**WELWYN HATFIELD BOROUGH COUNCIL
ASSISTANT DIRECTOR (PLANNING)**

DELEGATED APPLICATION

Application No: 6/2024/0721/PN10
Location: Chestnut Farm Woodfield Lane Hatfield AL9 6JJ
Proposal: Prior approval for a change of use from agricultural building to one dwellinghouse
Officer: Ms Elizabeth Mugova

Recommendation: Prior Approval Required and Refused

Drawing Title  
 Agricultural Storage Barn  
 Plans and Elevations  
 Proposed

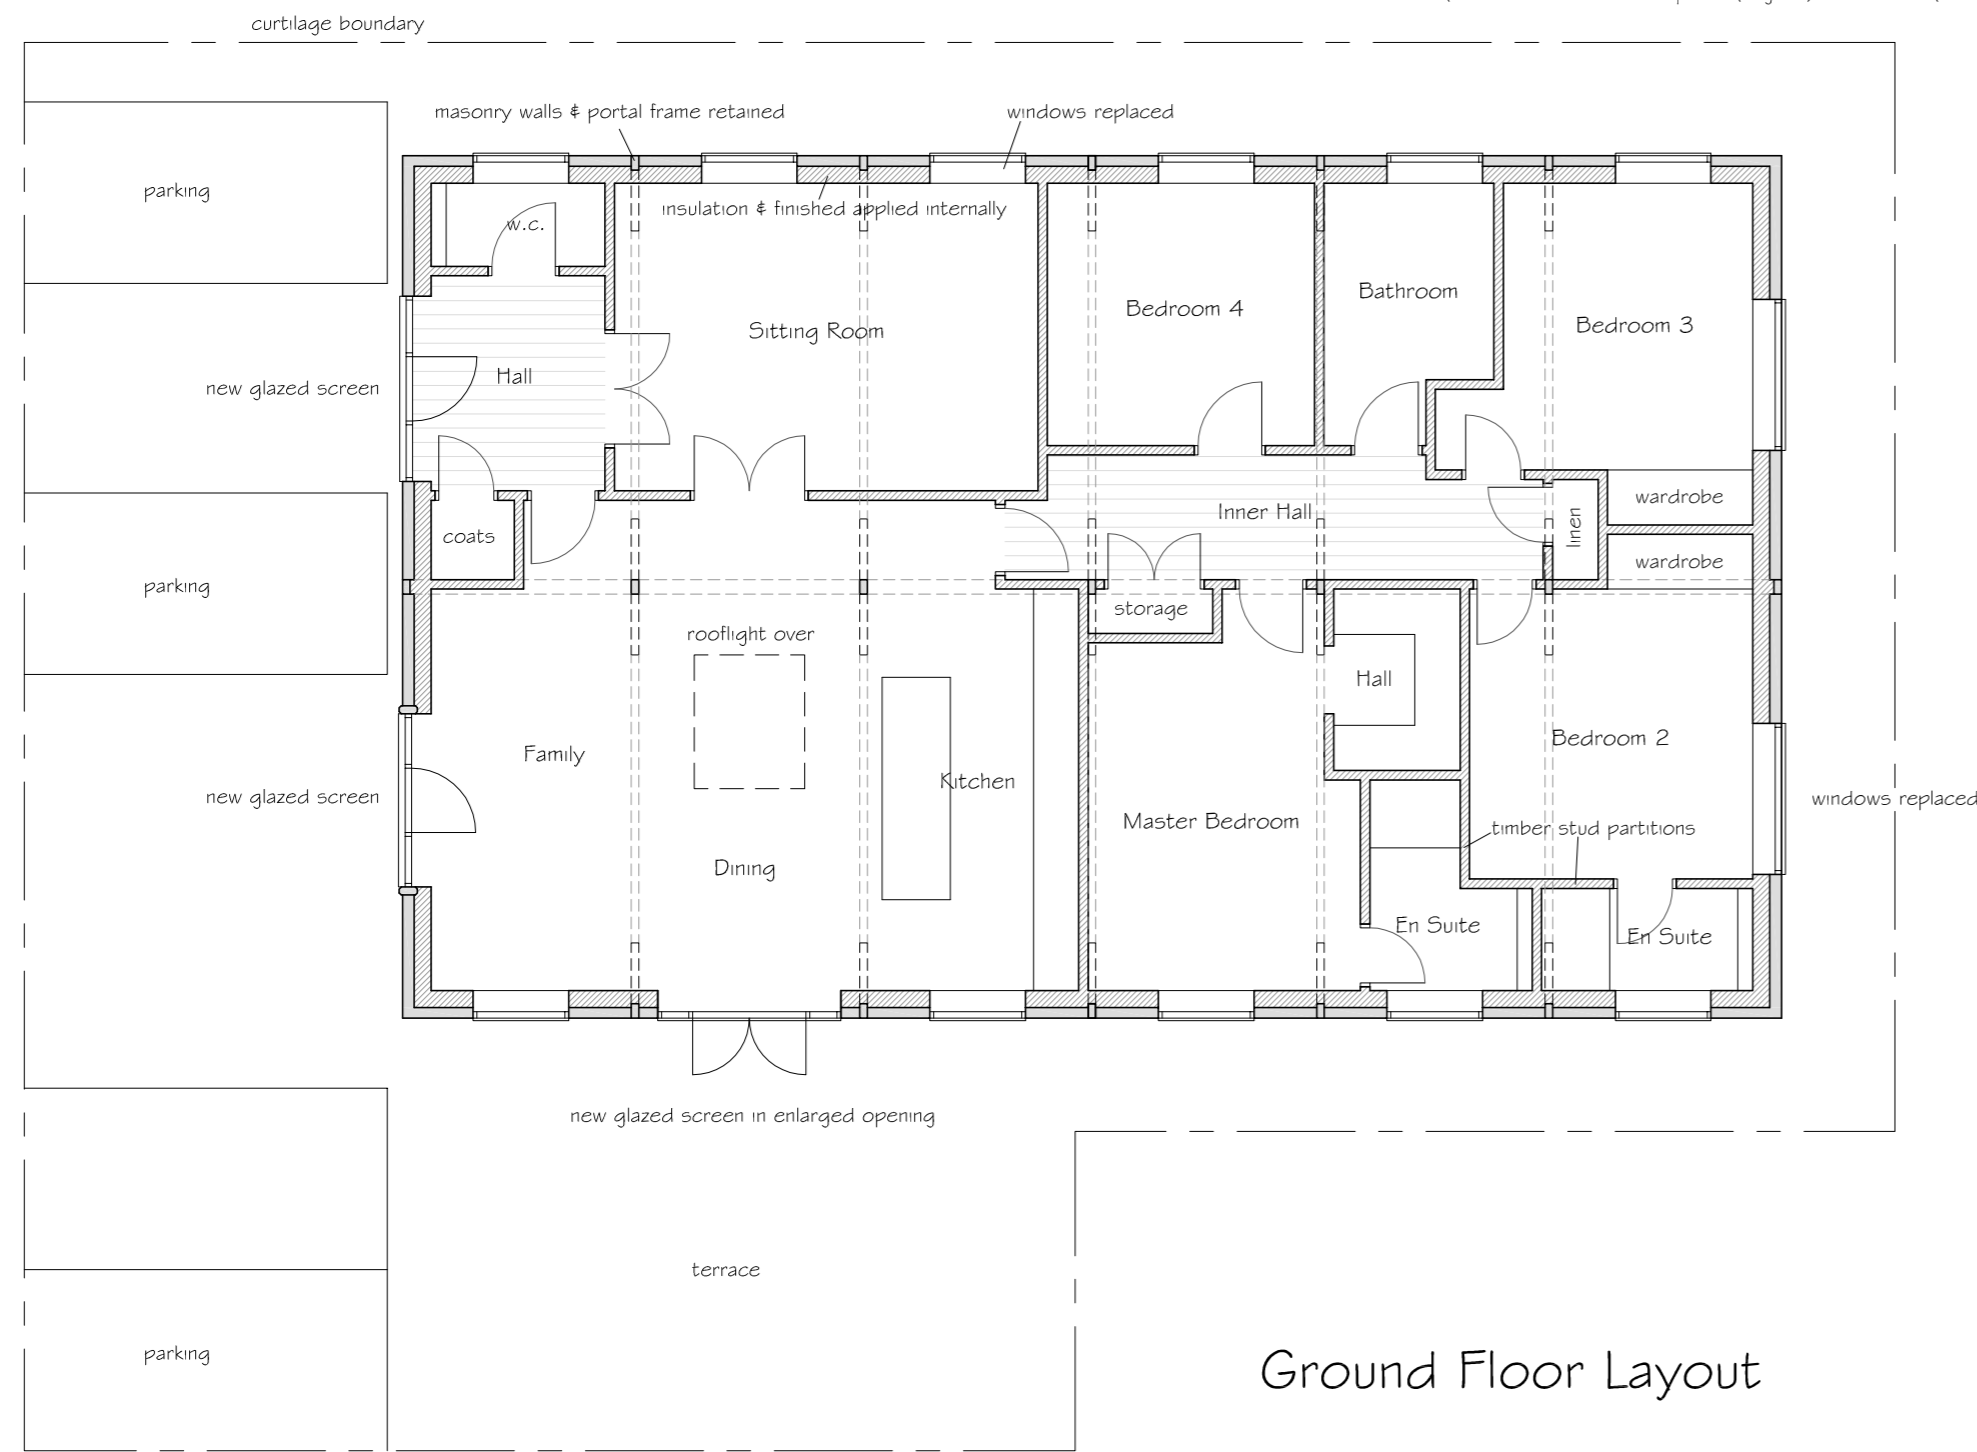
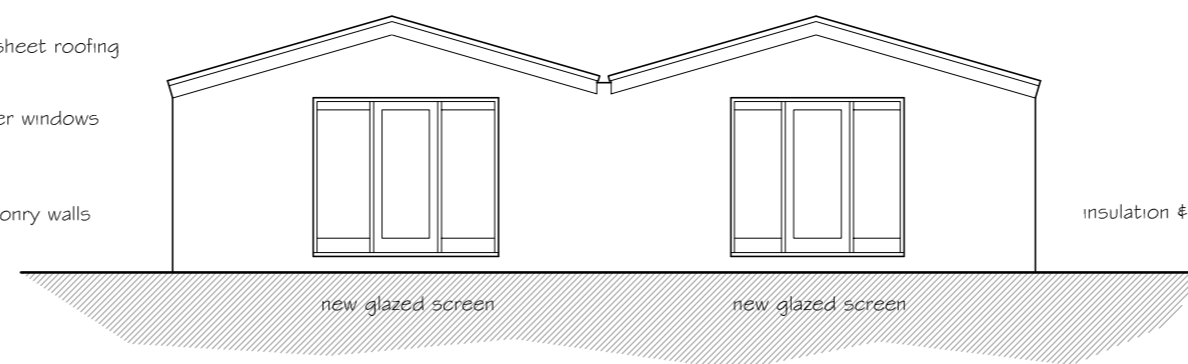
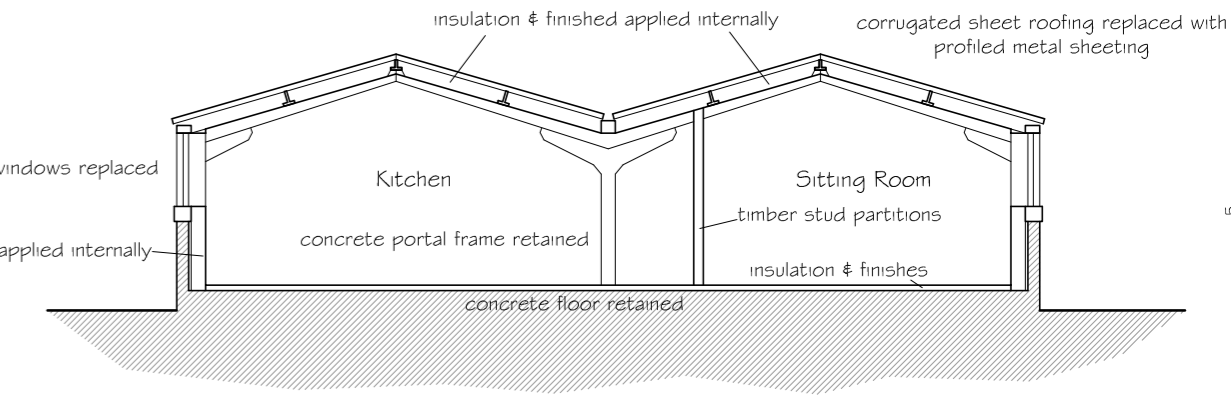
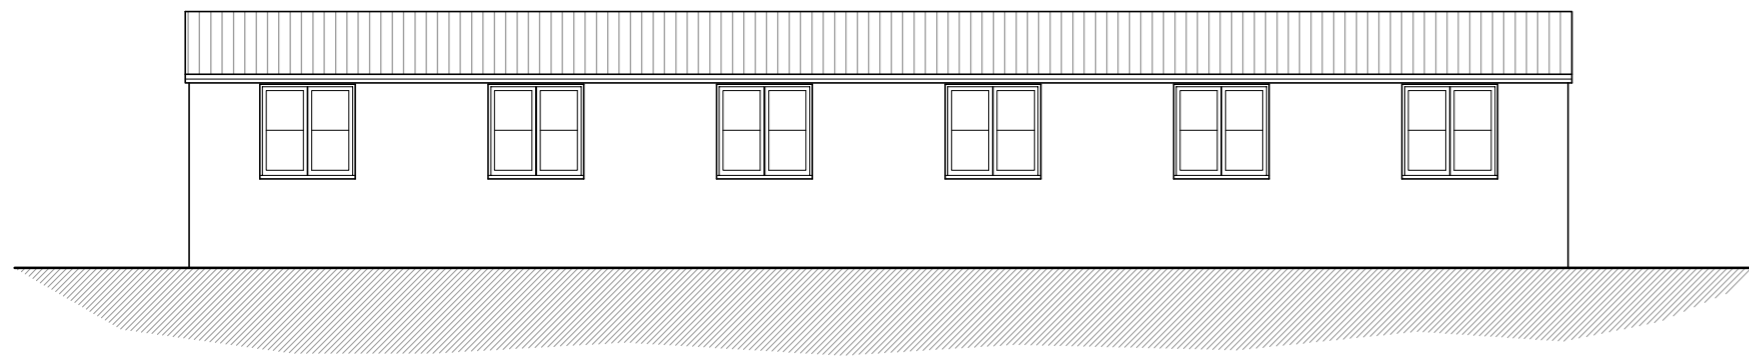
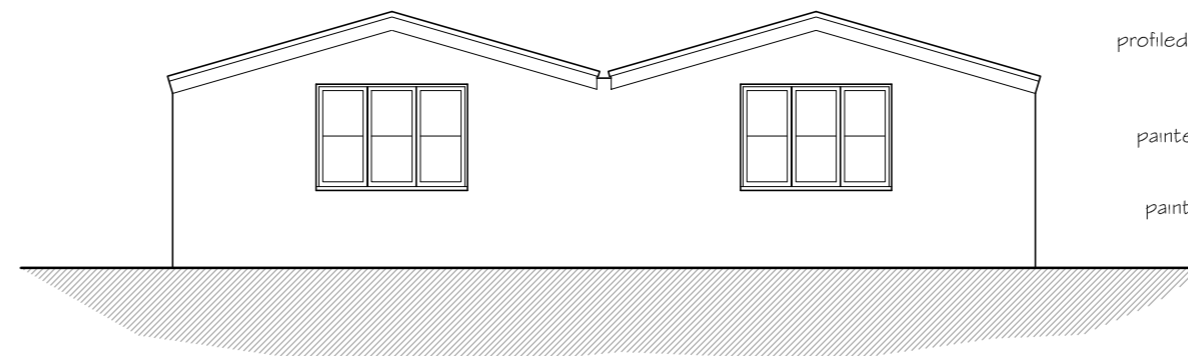
<p>The design or external appearance of the building</p>	<p>The proposed dwelling would feature metal sheet roofing, painted masonry walls and the concrete framed windows would be replaced by painted timber windows. The proposed external materials are considered acceptable in this rural location.</p>
<p>The provision of adequate natural light in all habitable rooms of the dwellinghouses</p>	<p>The GPDO clarifies that "habitable rooms" means any rooms used or intended to be used for sleeping or living which are not solely used for cooking purposes, but does not include bath or toilet facilities, service rooms, corridors, laundry rooms, hallways or utility rooms.</p> <p>The design of the proposed conversion with new external doors and windows allows maximum levels of daylight to be provided to the deeper areas of the floor plan which is enhanced through the provision of a roof light on the inward facing roof slope.</p>

The proposed dwelling would exceed the 37sqm minimum figure and the nationally described space standard for a 4-bedroom, 8-person house which is a single storey (117sqm).
